**ADC Planning Consultation
Conservation/Design Officer Response**

Application Number	LU/50/17/PL
Address	70 High Street, Littlehampton
Description	Alteration to a Building of Special Character, adjacent to a listed building
Case Officer	David Easton
Date	10 May 2017

location plan scale: 1:1250

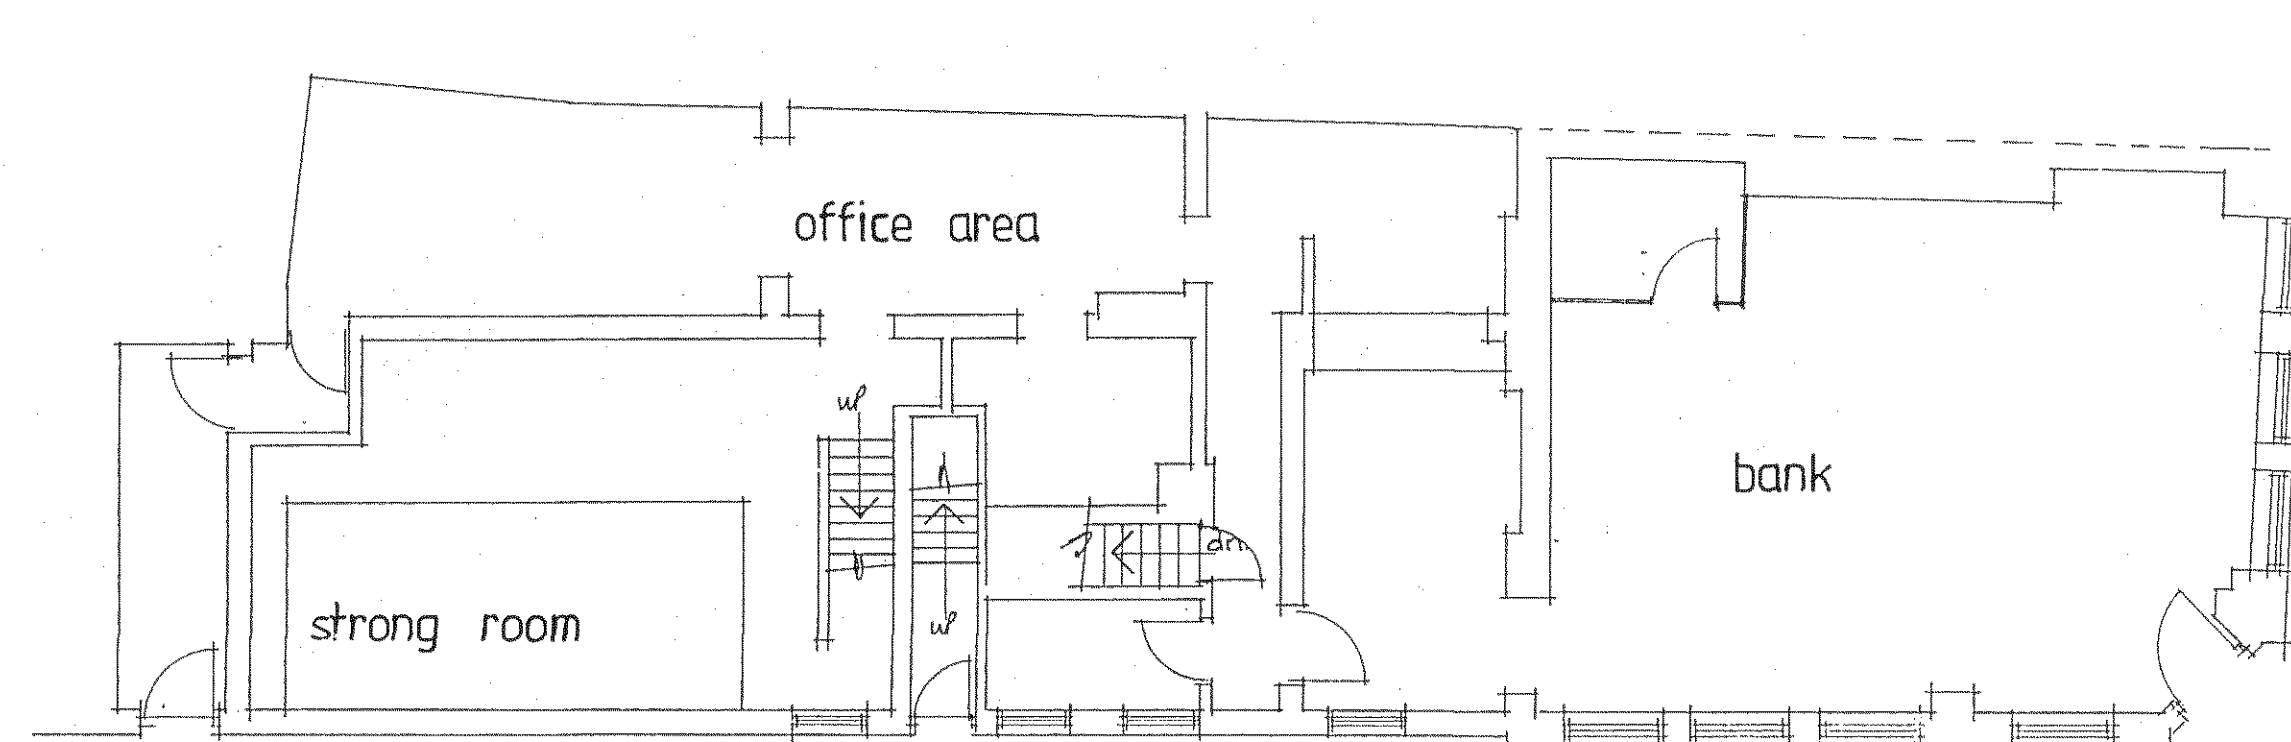
70 High Street is designated as a building of Special Character and it is located in close proximity to a Grade II listed building. The presence of the proposed dormer will cause no harm to the significance of the neighbouring listed building and there is no objection in terms of Policy HER DM1. However, the host building is locally listed and the proposed bulky dormer diminishes its aesthetic quality. While a modestly scaled dormer of traditional proportions may be possible in this location, the bulky structure now proposed has an overbearing presence which unbalances the rear elevation of the host building.

Architectural Designs Bank Chambers 29, High Street Ewell, Surrey, KT17 1SB. Telephone: 0800 331 7732
Project: No 70 High Street Littlehampton
Title: Proposed new dormer window to the rear roof slope
Scale: 1:100
Date: December 2015
Drawing No: 1511-1888

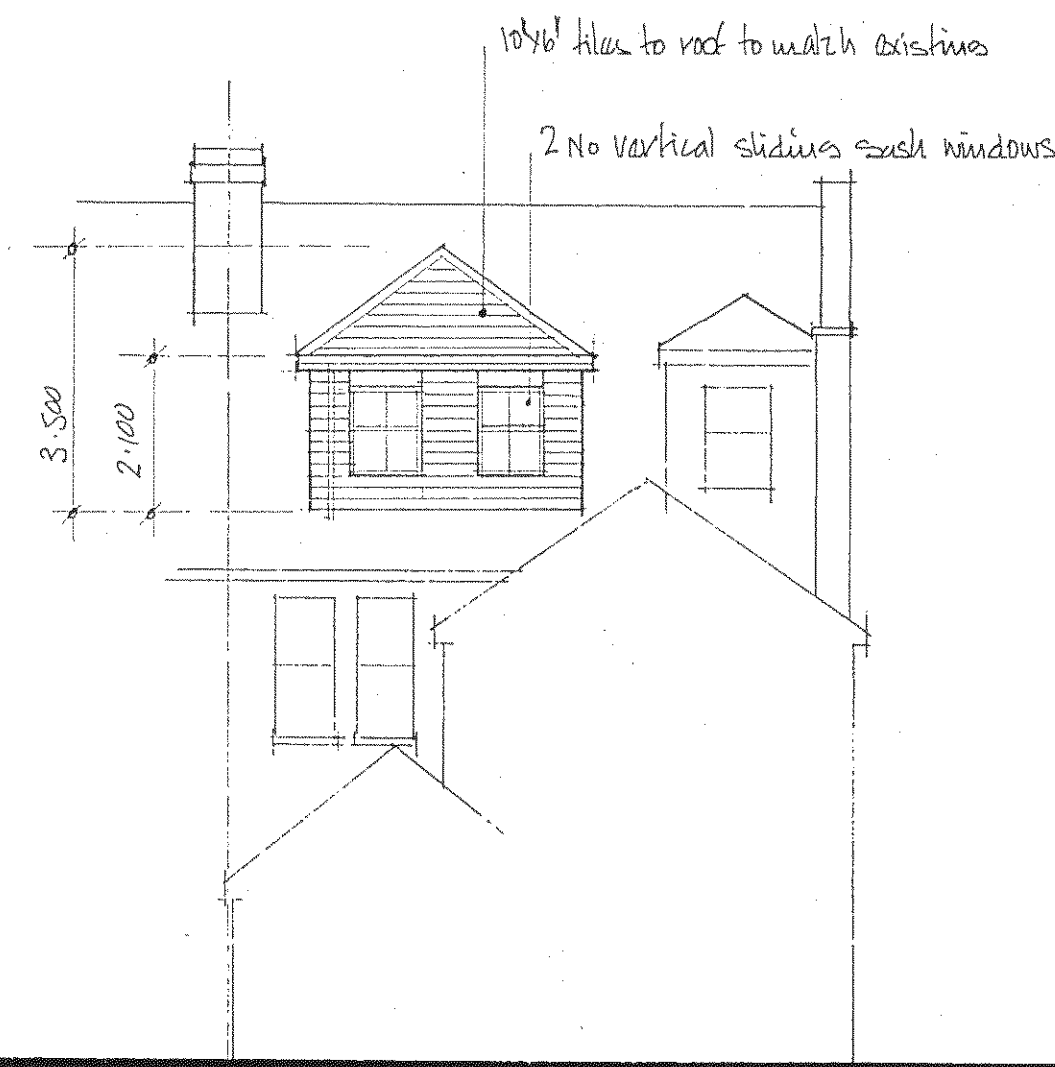
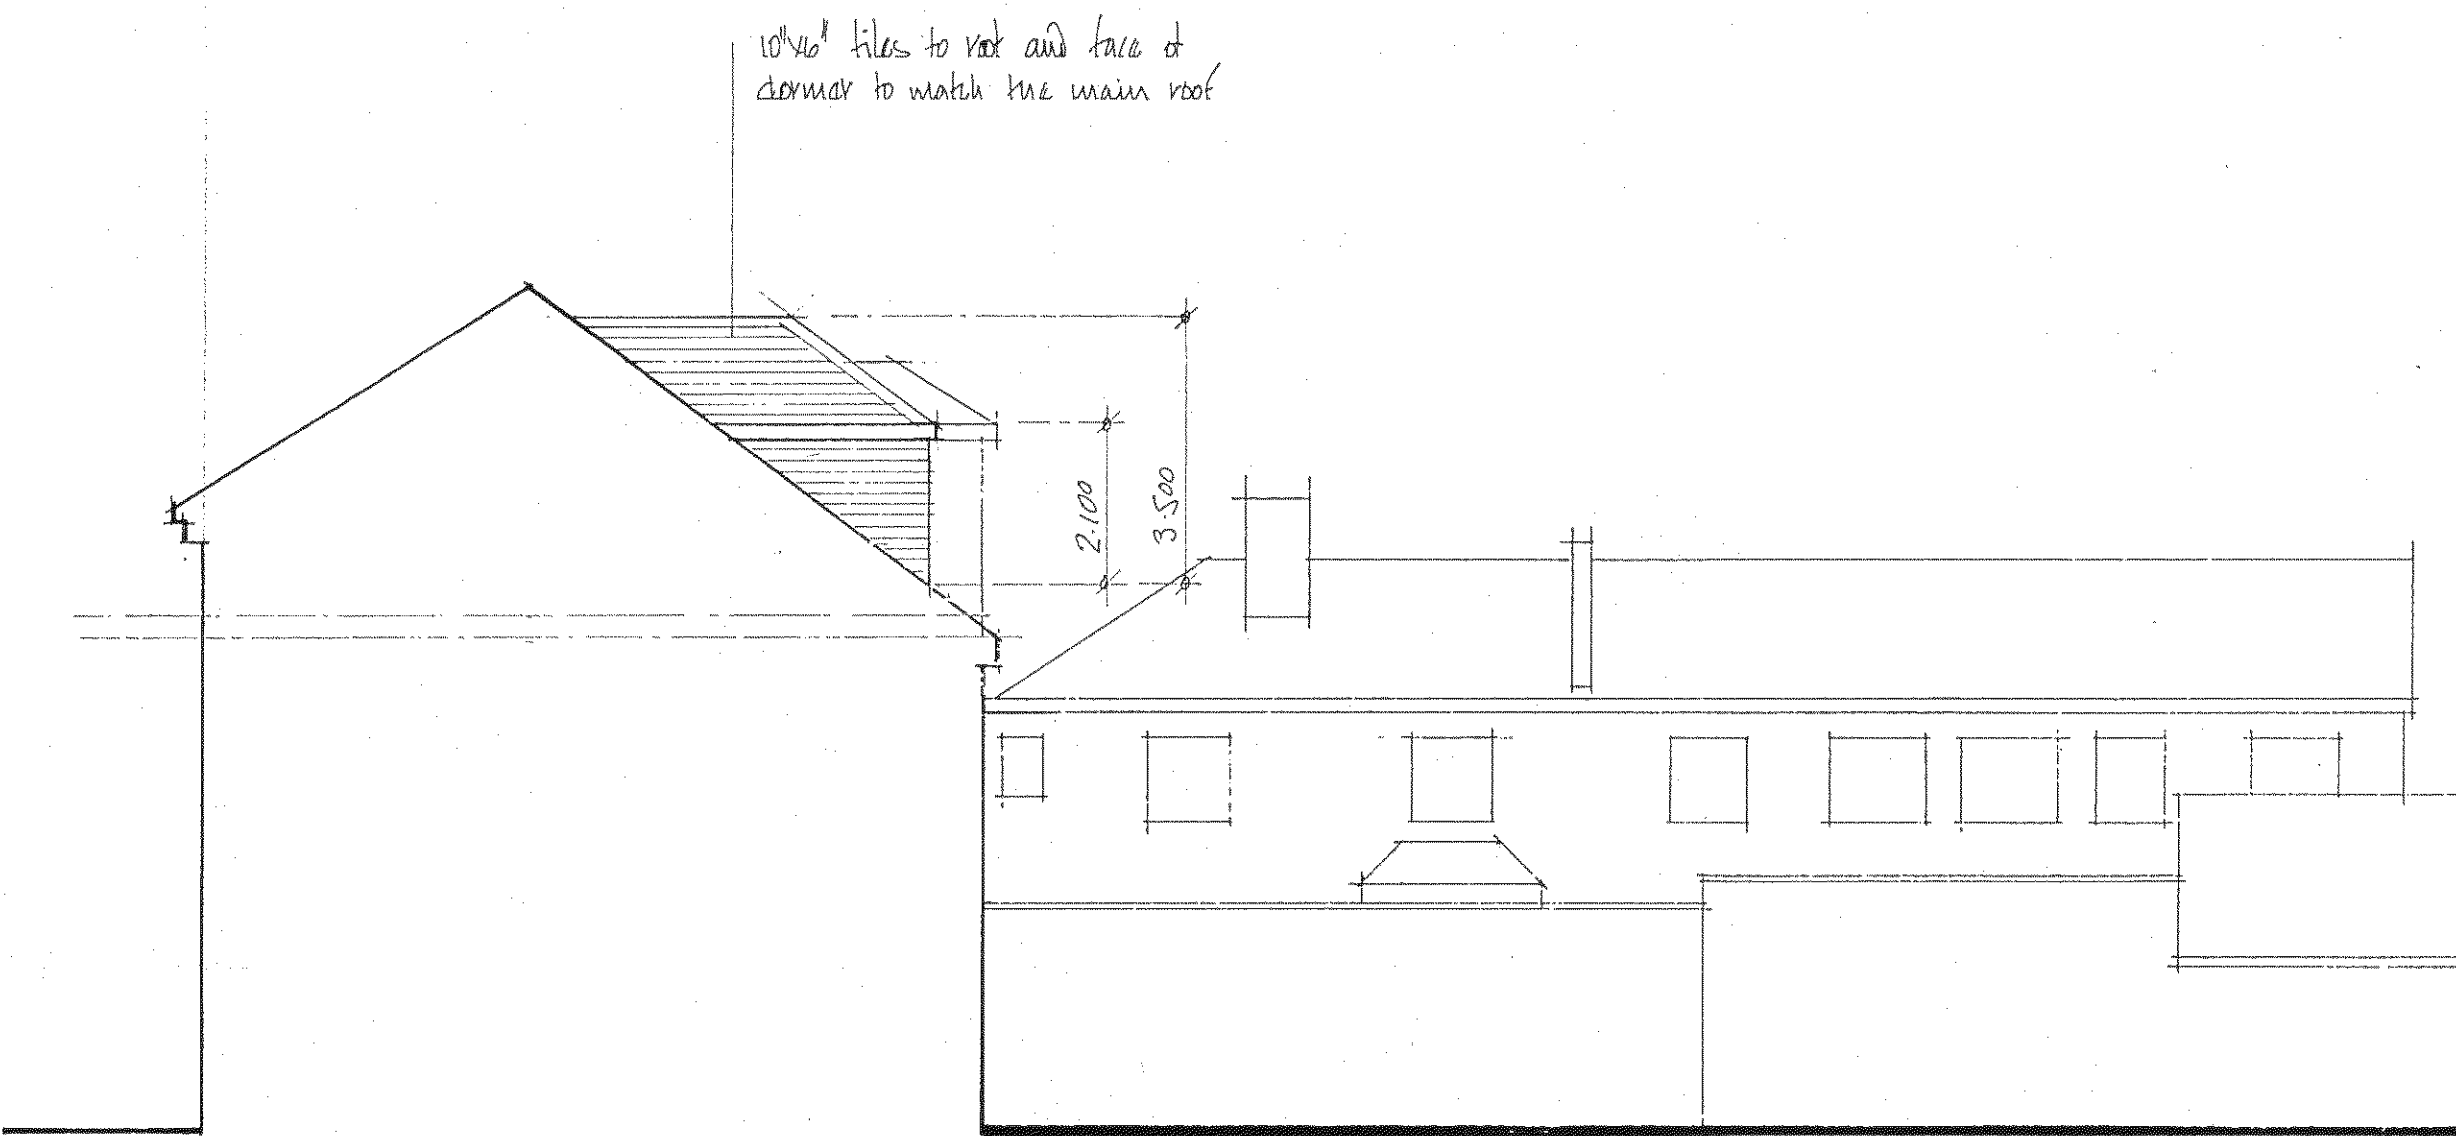
The exceedingly poor precedent at the attached, locally listed building to the west does not justify further unsympathetic work, as the cumulative effects further harm the locally distinctive qualities of the Buildings of Special Character.

The present proposal harms the significance of the locally listed building and refusal is recommended in terms of Policy HER DM2.
